22 May 2015

**PROPOSED CAR WASH FACILITY
CORMORANT ROAD KOORAGANG (DA 6988)**

I refer to your letter of 23 April 2015 seeking Council's comments on the above proposal.

Project  
**KOORAGANG CAR WASH**  
 Part Lot 1 DP 1195449 - 130 CORMORANT ROAD Cnr. EGRET STREET  
**KOORAGANG NSW**  
 FOR  
**SOVECHLES DEVELOPMENTS Pty Ltd**  
 Drawing Title  
 CAR WASH POLLUTION CONTROL SCHEMATIC

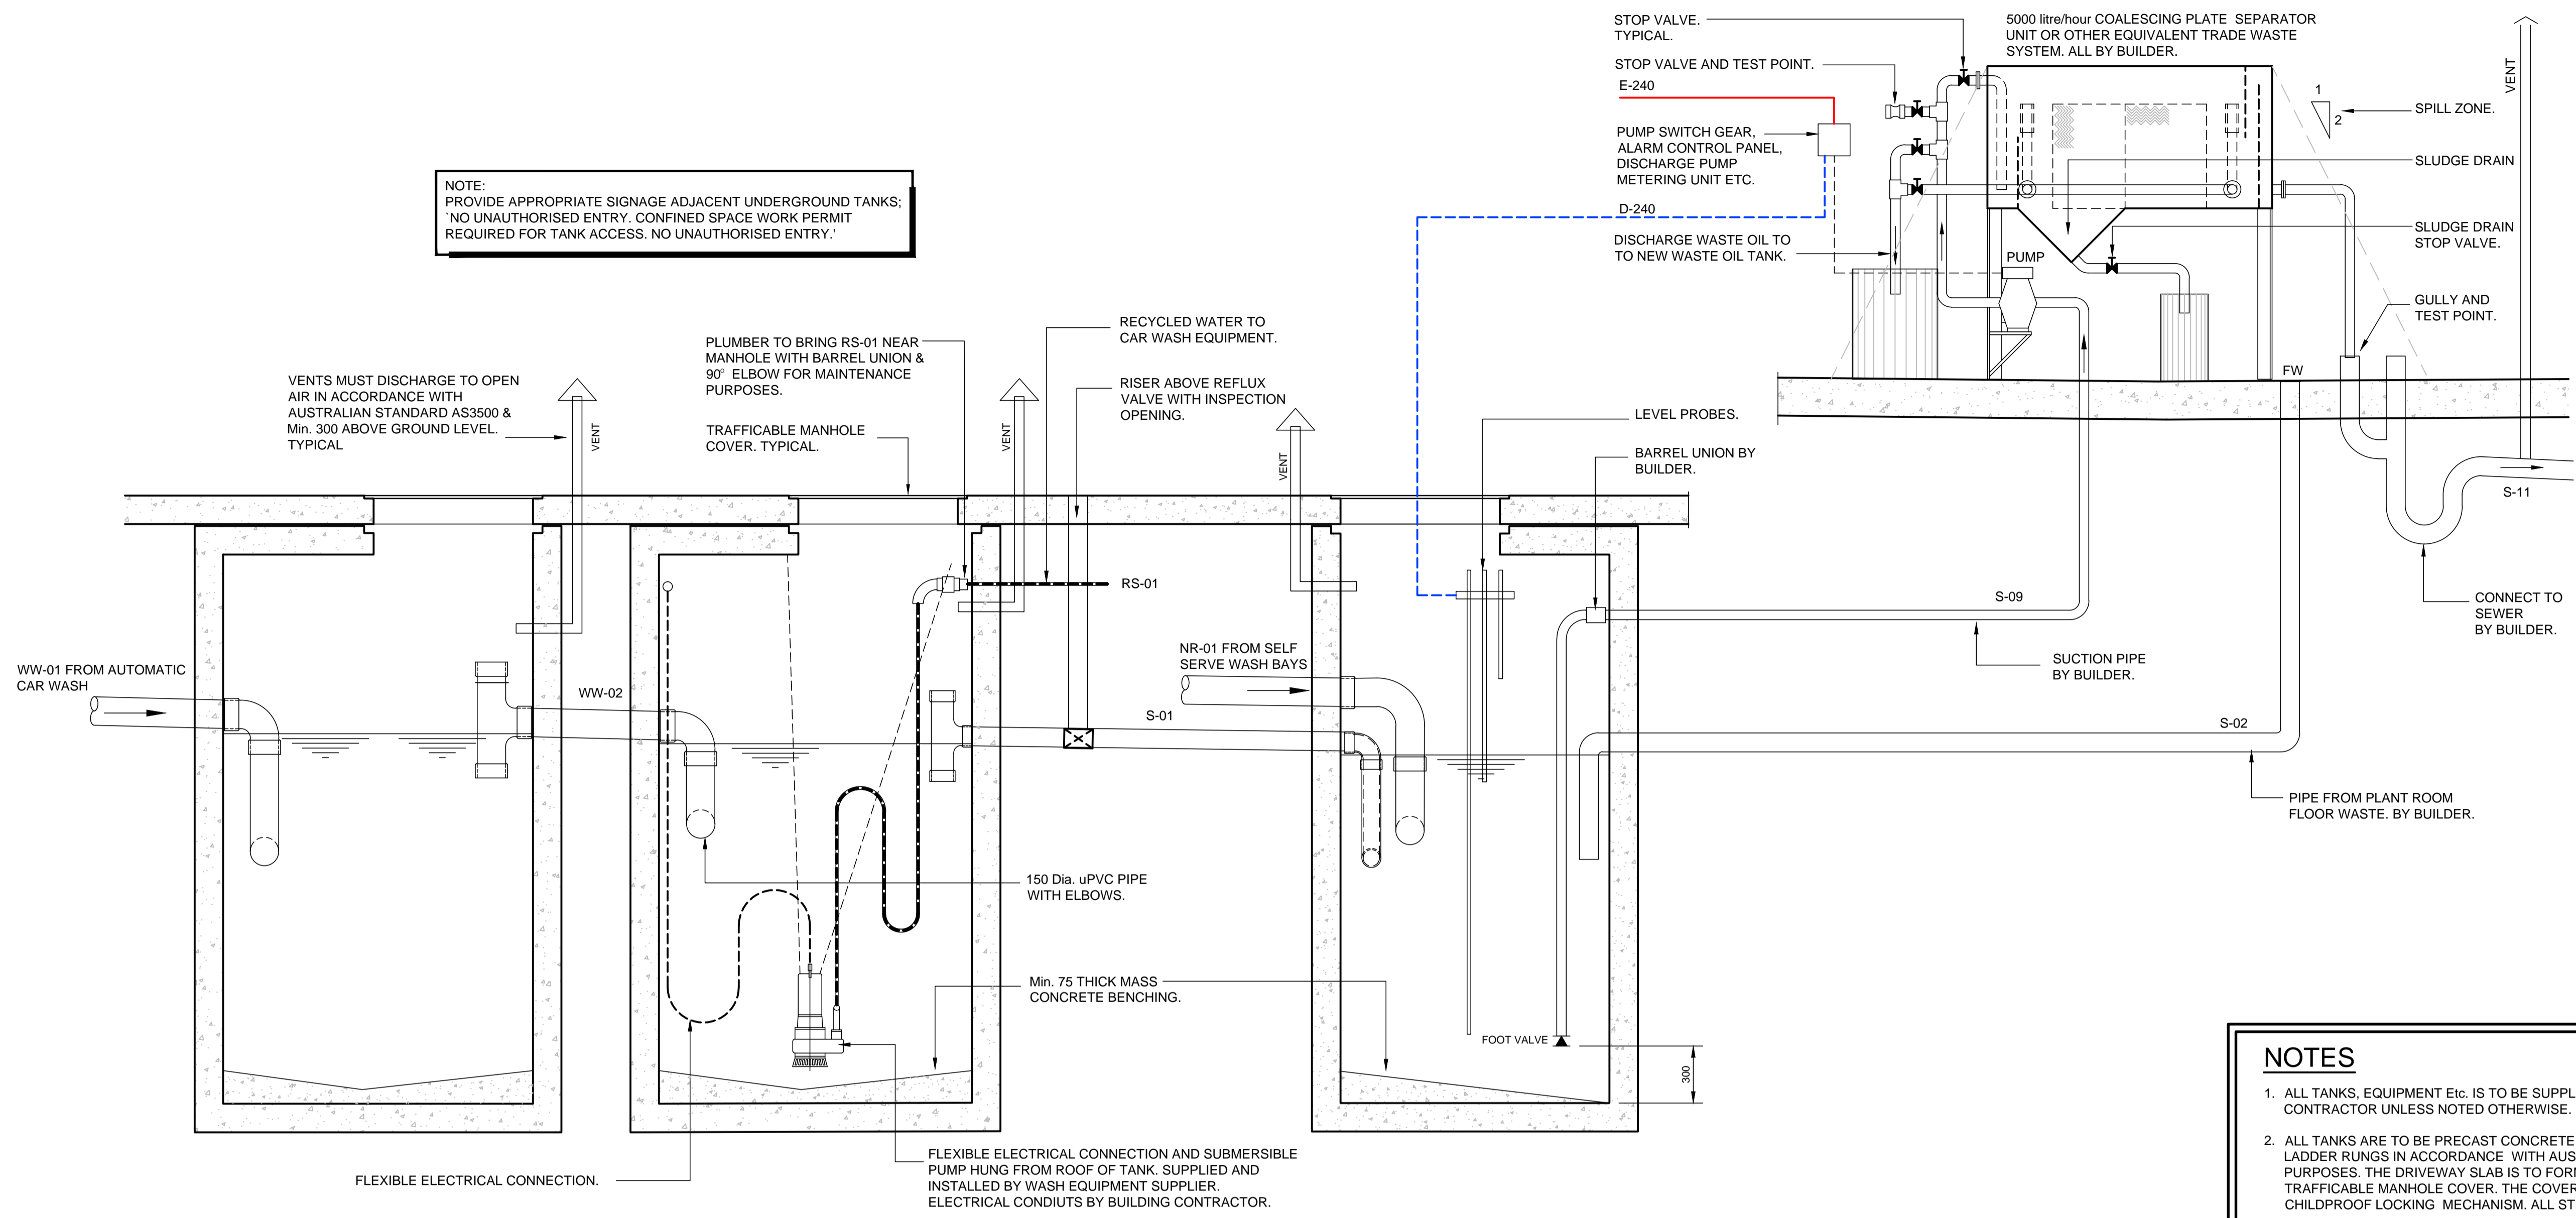
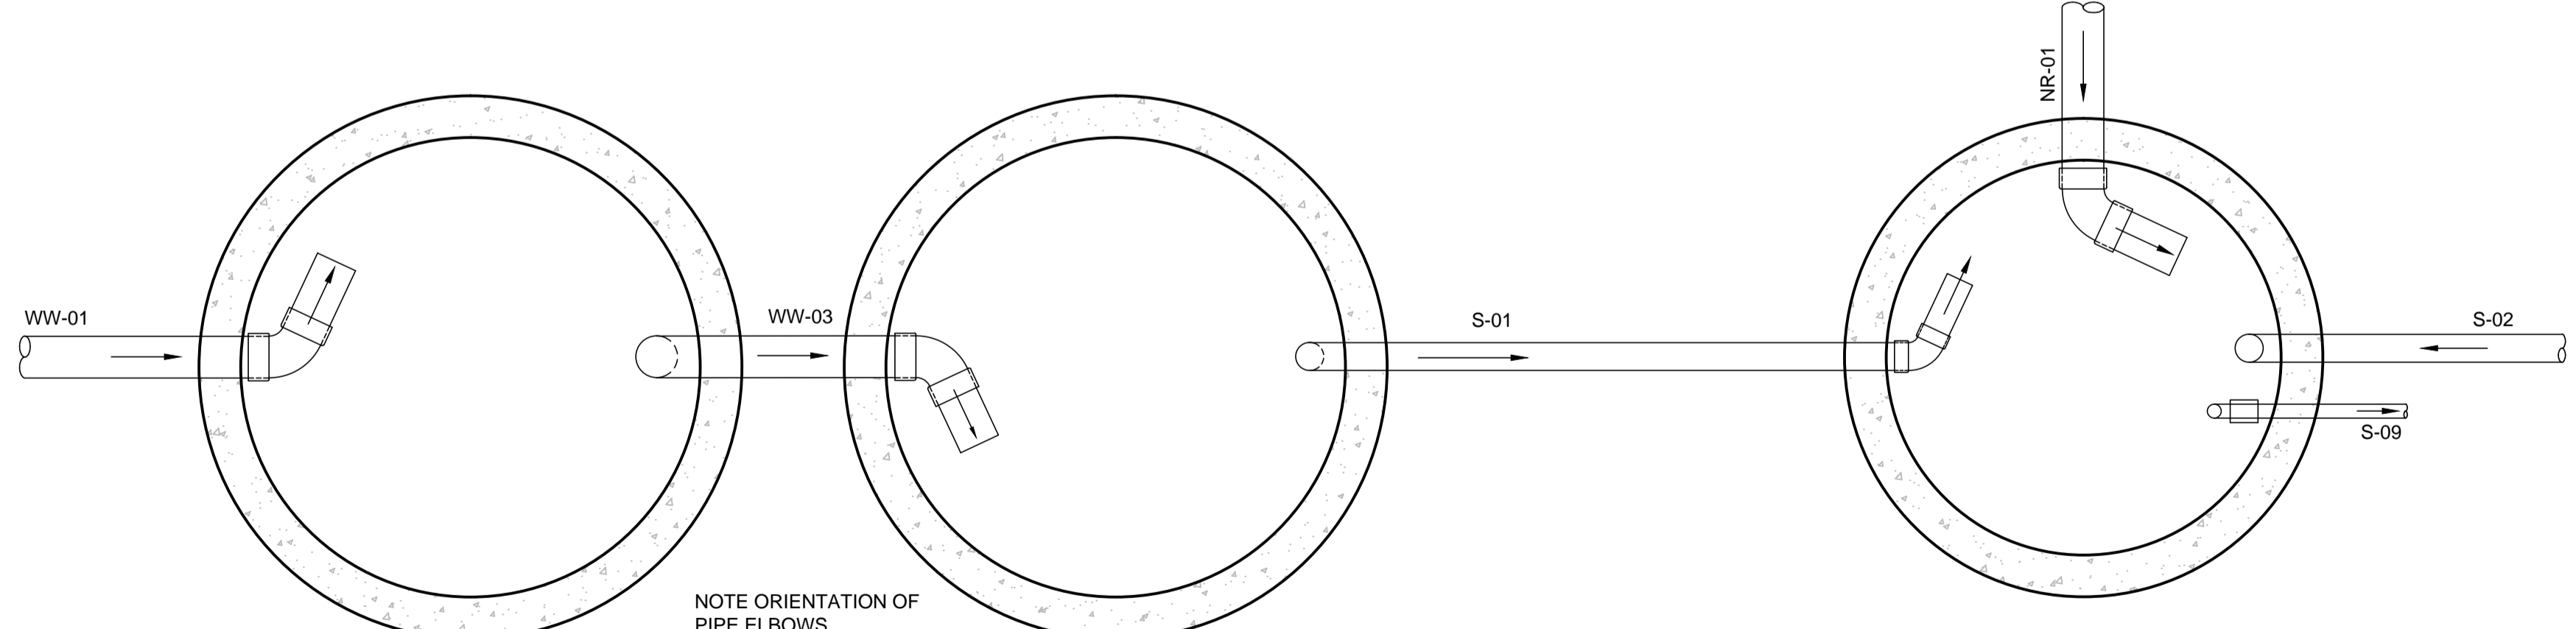
Telephone enquiries made to the Hunter Water Corporation, regarding the availability of sewer, indicated that sewer will become available in a few months time, following the carrying out of works to extend a sewer connection to the site.

Having regard for the nature of the proposal and constraints on options for on-site sewage management systems, the availability of a connection to a reticulated sewer system is considered to be a critical aspect of the proposed development.

Project
KOORAGANG CAR WASH
Part Lot 1 DP 1195449 - 130 CORMORANT ROAD Cnr. EGRET STREET
KOORAGANG NSW
FOR
SOVECHLES DEVELOPMENTS Pty Ltd
Drawing Title
CAR WASH STORMWATER DRAINAGE PLAN

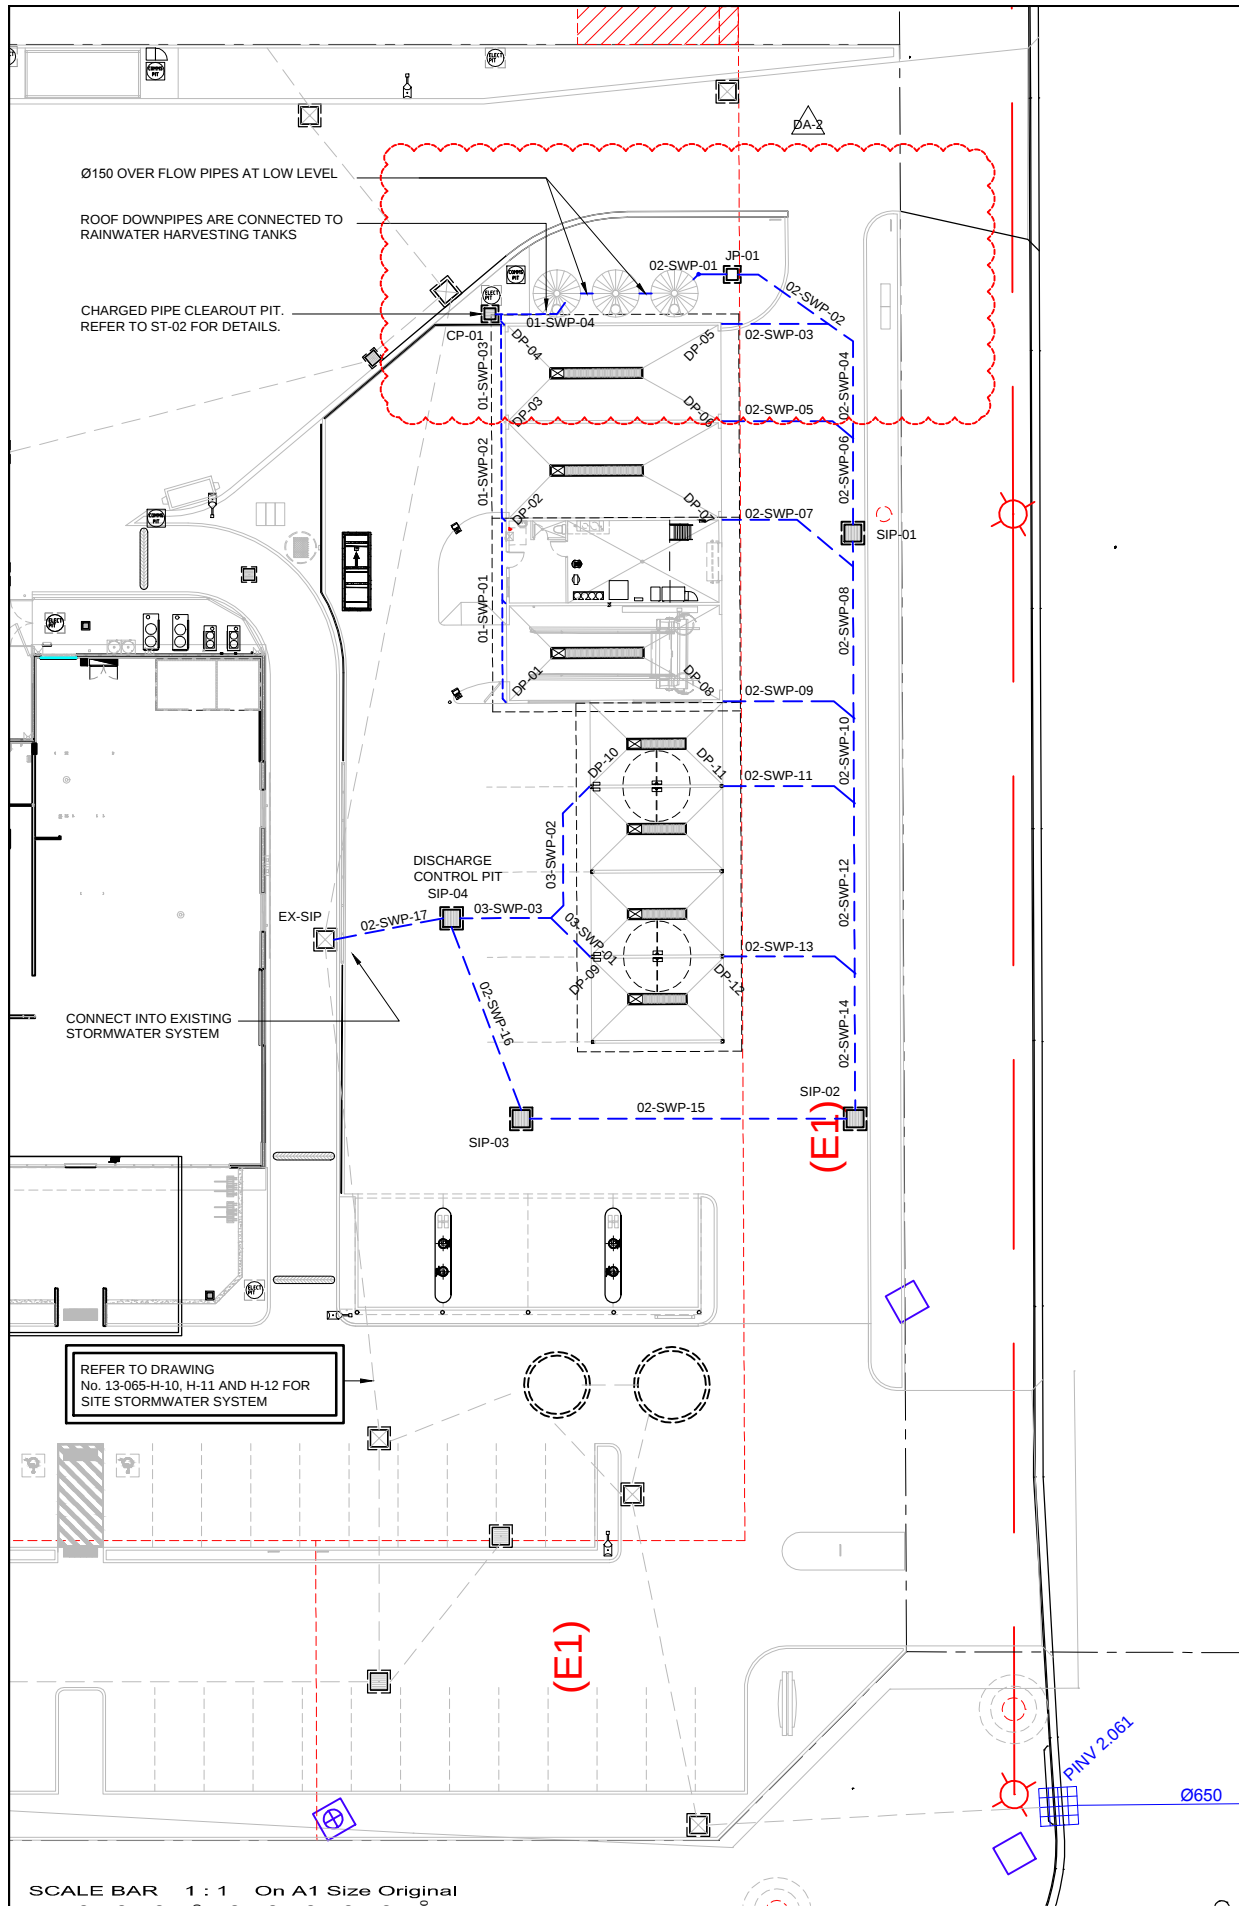
The submitted Site Stormwater Drainage Plan provides for integration with the stormwater drainage system proposed for the previously approved service station.

Stormwater reuse, onsite detention and water quality treatment units are proposed to control site discharge for quantity and quality which, according to the details provided, satisfy the requirements of Council's Development Control Plan.

- All on-site stormwater detention or water quality treatment systems be individually identified and sign posted in accordance with Council's Stormwater and Water Efficiency for Development Technical Manual (Updated 2013).

- A Maintenance Manual for all water quality devices be prepared in accordance with Council's Stormwater and Water Efficiency for Development Technical Manual (Updated 2013). The Maintenance Manual should address maintenance issues concerning the water quality devices including routine monitoring and regular maintenance and be kept on site at all times. Establishment and maintenance of the water quality devices in accordance with the Maintenance Manual should be completed prior to occupation of the site for the intended use.

- A copy of the stormwater drainage design plans approved with the Construction Certificate with 'work as executed' levels indicated, be submitted to the Principal Certifying Authority and to Newcastle City Council prior to the issue of an Occupation Certificate. The plans should be prepared by a Practising Professional Engineer or Registered Surveyor experienced in the design of stormwater drainage systems.
